From: De-Ruyck, Chris <Chris.De-Ruyck@e-lindsey.gov.uk>
Sent: 21 September 2026 16:54
To: Niland, Mark; Hill, Grace (ELDC)
Cc: _planningadvice; Atkinson, Nick
Subject: RE: Urgent Consultation Response

H16-0515-25 - Land at Horseshoe Road Spalding PE11 3JB
Planning Permission - Residential development of 76 dwellings and associated infrastructure

Documents reviewed:

Horseshoe Road, Spalding: Overall Masterplan. LS01 (1:500 @A1)

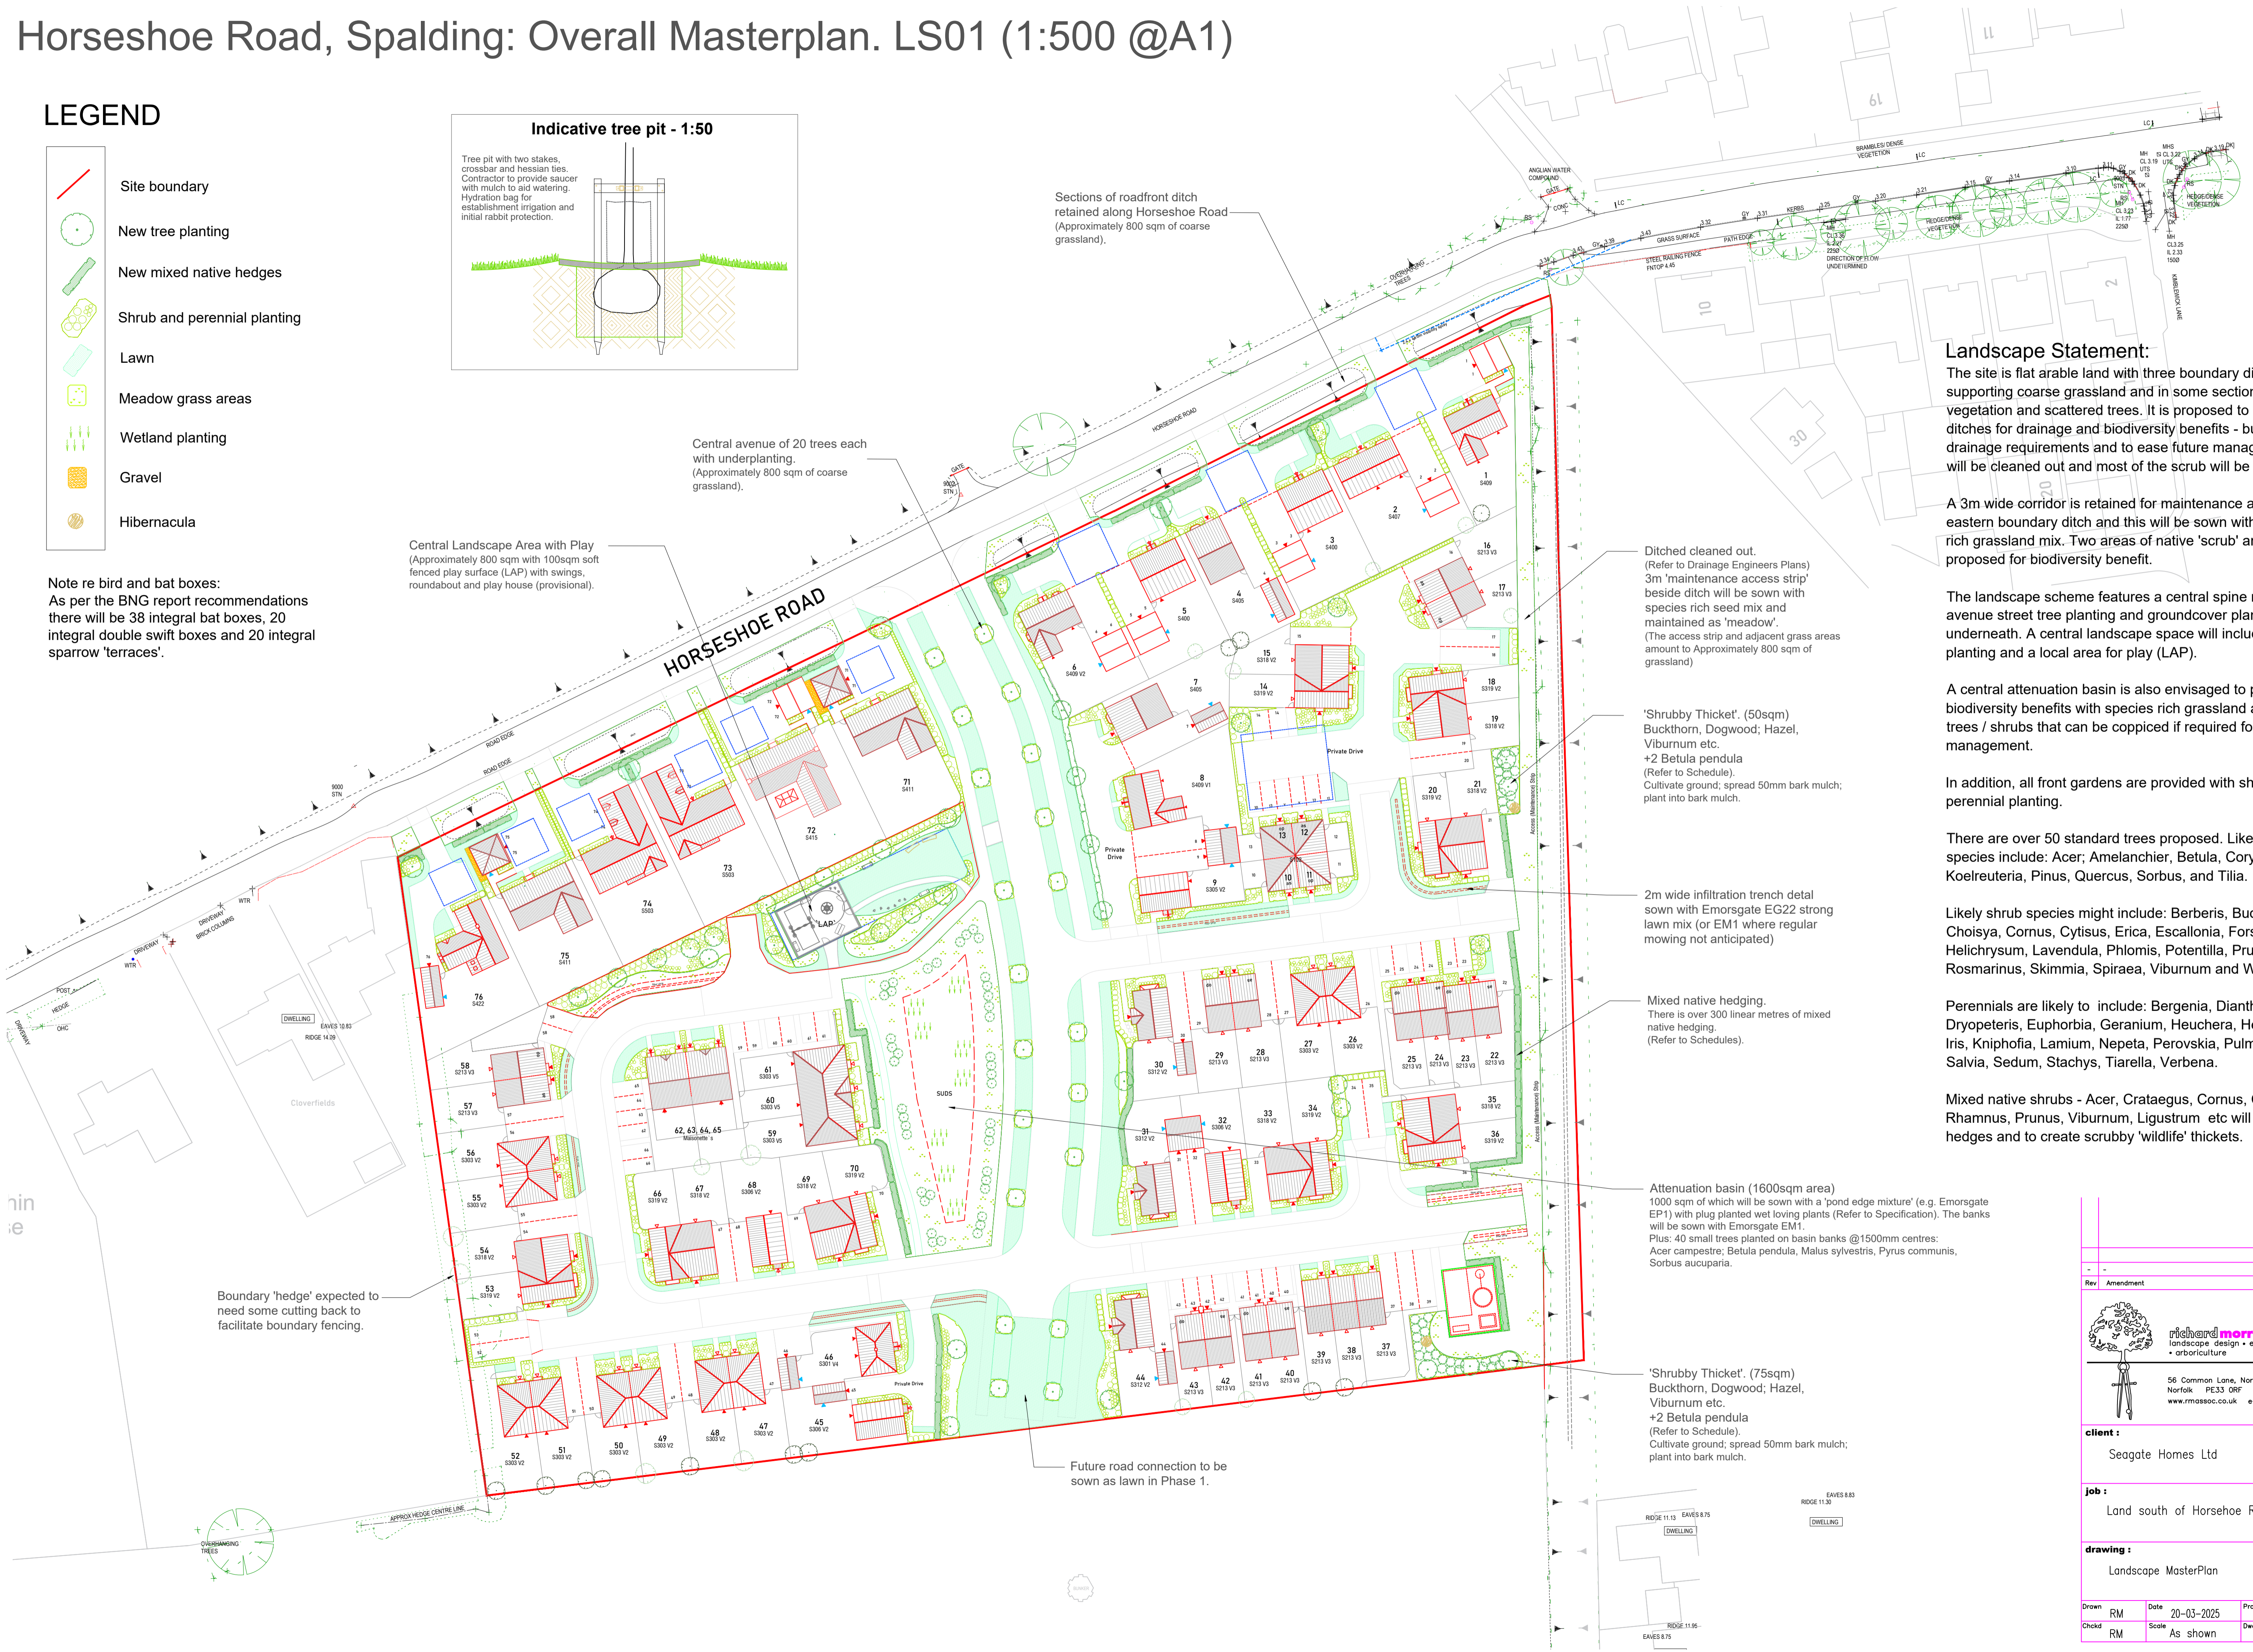
- The issue lies around the locations and habitat condition targets of “Other Neutral Grassland” in the development plans.
 - There is one section of other neutral grassland (G16) with a habitat target condition of “good”, and we request that this section of grassland be changed to ‘moderate’ due to the negative impacts arising from urban pressures such as: additional footfall; pets (primarily dogs and cats) will impact wildlife, generate physical damage, and potentially introduce invasive species; road traffic may similarly impact wildlife; and herbicide/insecticide use on or nearby may impact plants and insects. In addition, a lack of connectivity and fragmentation/edge effects would also likely reduce the plant, invertebrate, and wildlife populations supported in these areas. Thus, all things being equal, these isolated and relatively small grassland habitats located in urban developments will generally satisfy fewer habitat condition criteria and support less biodiversity than an equivalent habitat located further away from urban impacts and/or in larger contiguous patches. Additionally, many of the impacts listed above cannot be effectively mitigated against through management and will be cumulative over time.

- The post-development plans also indicate that “other neutral grassland” (ONG) will be planted in some areas where it isn’t feasible/appropriate, and these areas should be recorded as “modified grassland” in moderate condition instead (please see red

circled areas in map below for examples). Other Neutral Grassland requires continued effort to create, monitor, and manage this habitat type over the long term (e.g., possible nutrient reduction measures needed initially, sowing with appropriate species rich mixture, no mowing of these habitat blocks Mar-late July; complete removal of cuttings every one to two years (every year initially), etc., and there will be little room to adjust management regimes to meet the needs of residents over the 30 year period (e.g., demand for short grass amenity spaces, hay fever sufferers, pets, etc.,). In addition, in some places there do not appear to be clear boundaries between the public open space recorded as other neutral grassland and the private gardens/residential curtilage associated with the dwellings, and therefore these should be recorded as modified grassland or vegetated garden, rather than ONG.

Post-development map depicting areas that appear to be recorded as other neutral grassland, but which should be set to modified grassland within the post-development habitat tab of the metric.

Overall, I do not believe that the proposed habitat targets and current post-development BNG metric calculations account for the additional pressures that will impact these areas, and the metric calculations should be amended to better reflect these constraints, and provide some buffer to mitigate the risk against failing to achieve the intended targets. This will correspondingly require the applicants to secure a greater amount of off-site units than currently indicated to achieve the 10% biodiversity requirement.
